# Rezoning Transportation Analysis

Petition Number: 2021-085

## Revision Log:

Date	Description
08-02-2021	First Review (WB)

**SITE PLAN**

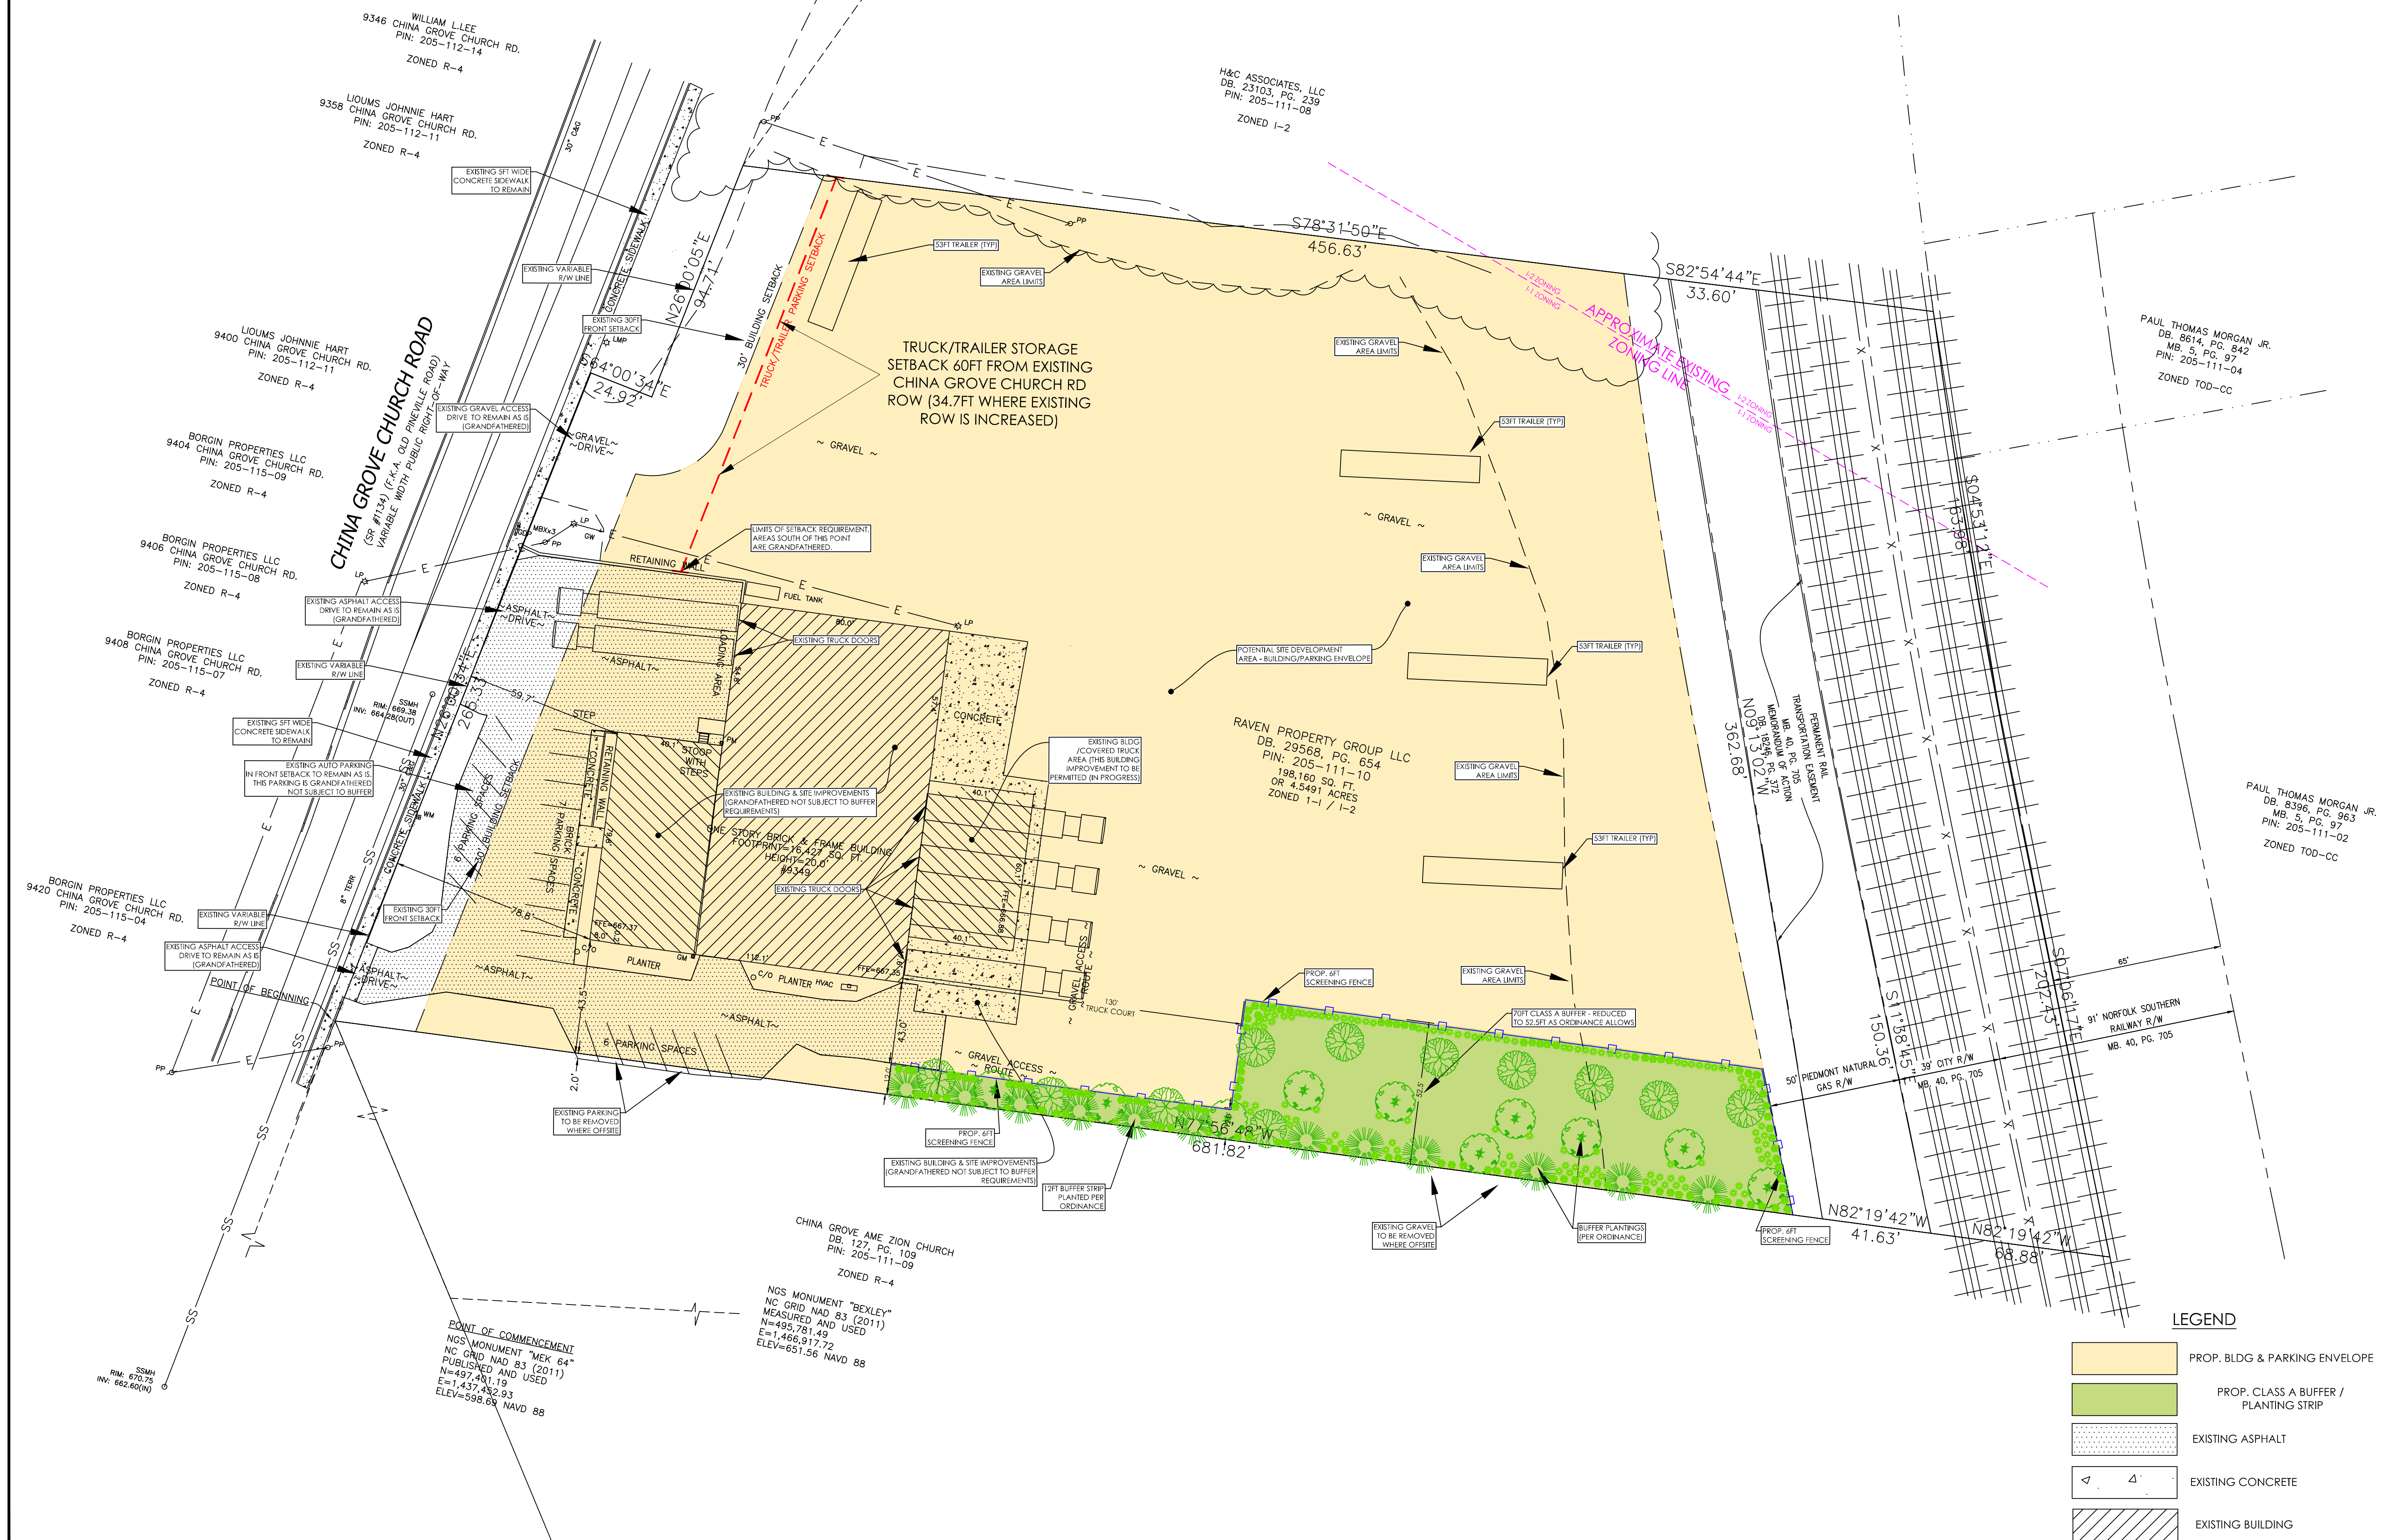
2. Revise site plan and conditional note(s) to commit to dedicate 36' right-of-way from the road centerline. The site plan shall label and dimension the right-of-way from the road centerline.

3. Revise site plan and conditional note(s) to commit to construct an 8-foot planting strip, and 5-foot minimum sidewalk on China Grove Church Road per CLDSM Standard U-07 and in accordance with Charlotte BIKES Policy. The site plan shall label and dimension both items from the back of curb and gutter and road centerline.
4. Site plan and conditional note(s) revisions are needed to remove all reference to all "grandfathered" infrastructure. All transportation infrastructure must be revised to meet current CDOT CLDSM standards, including driveway installation per the Charlotte Driveway Regulations.
